Our Ref: BE/11/17/HH

**Town & Country Planning Act 1990 (as amended)
Town & country Planning (Development Management Procedure) (England) Order 2015
Application for Planning Permission for Works or Extension to a Dwelling**

Development Conversion of garage into a bedroom, single storey rear extension and first floor front extension over garage

Location 40 Bursledon Close Felpham

PROPOSED ROOF PLAN

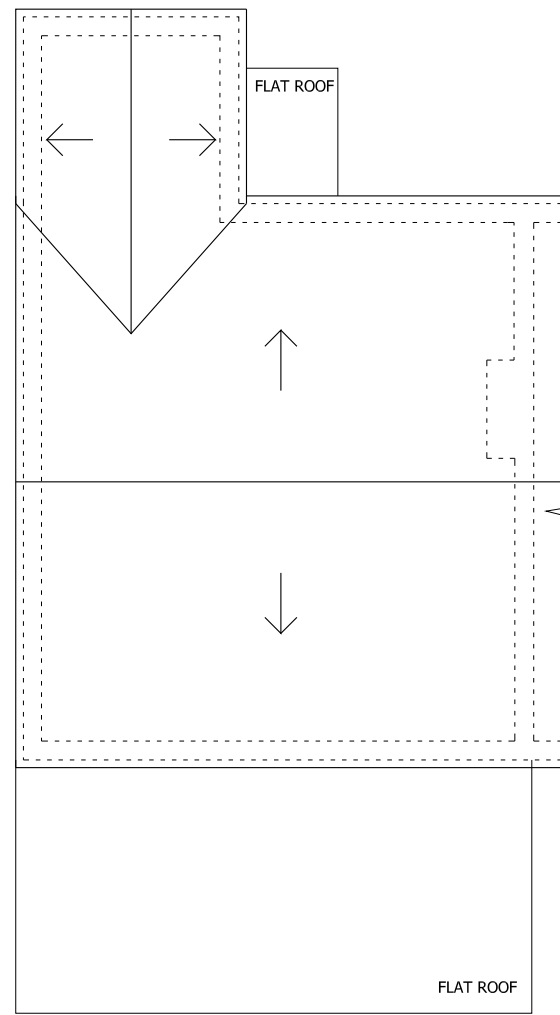
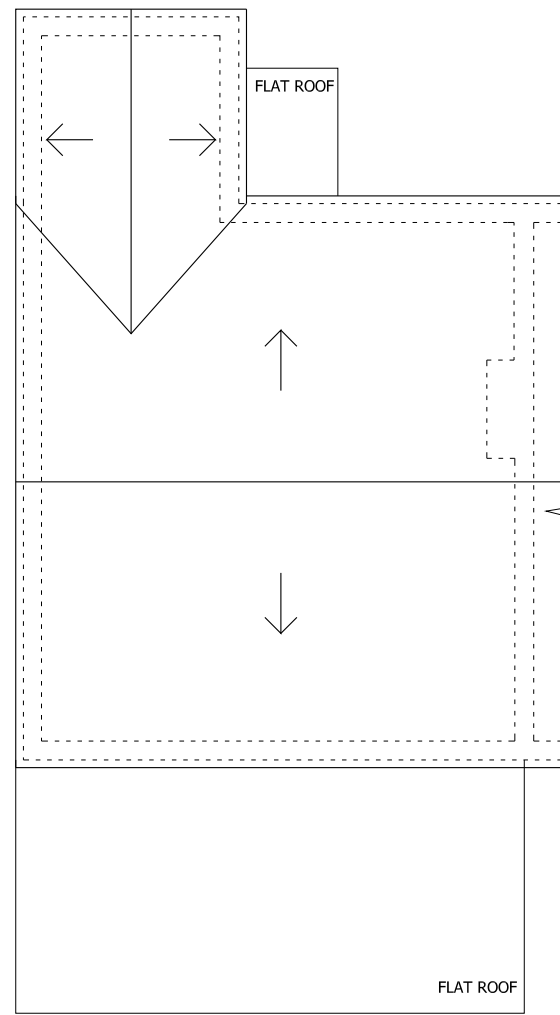
Roof Plan

Please submit 1 electronic or 3 paper copies of existing and proposed roof plan. Please refer to the National Validation Requirements for further details.

PROPOSED SITE PLAN, Sc. 1:500

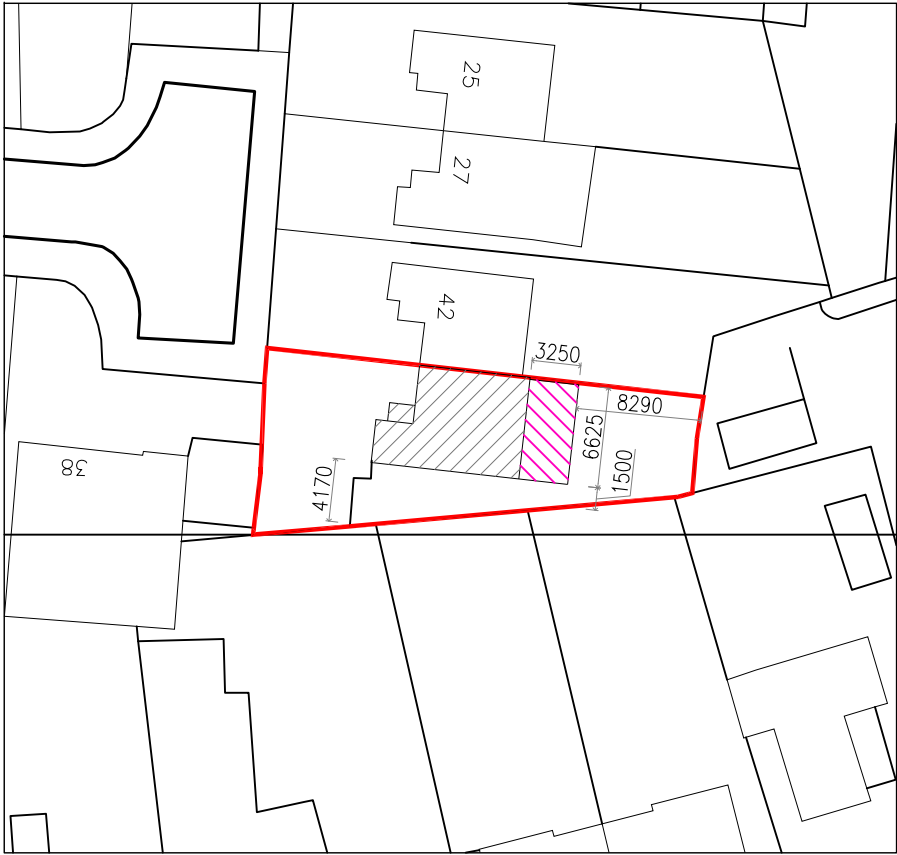
Block Plan

Please label the dimensions to demonstrate the distance from the proposal to the boundary lines

The pink areas on the block plan (namely the area to the side) is inconsistent with the other plans
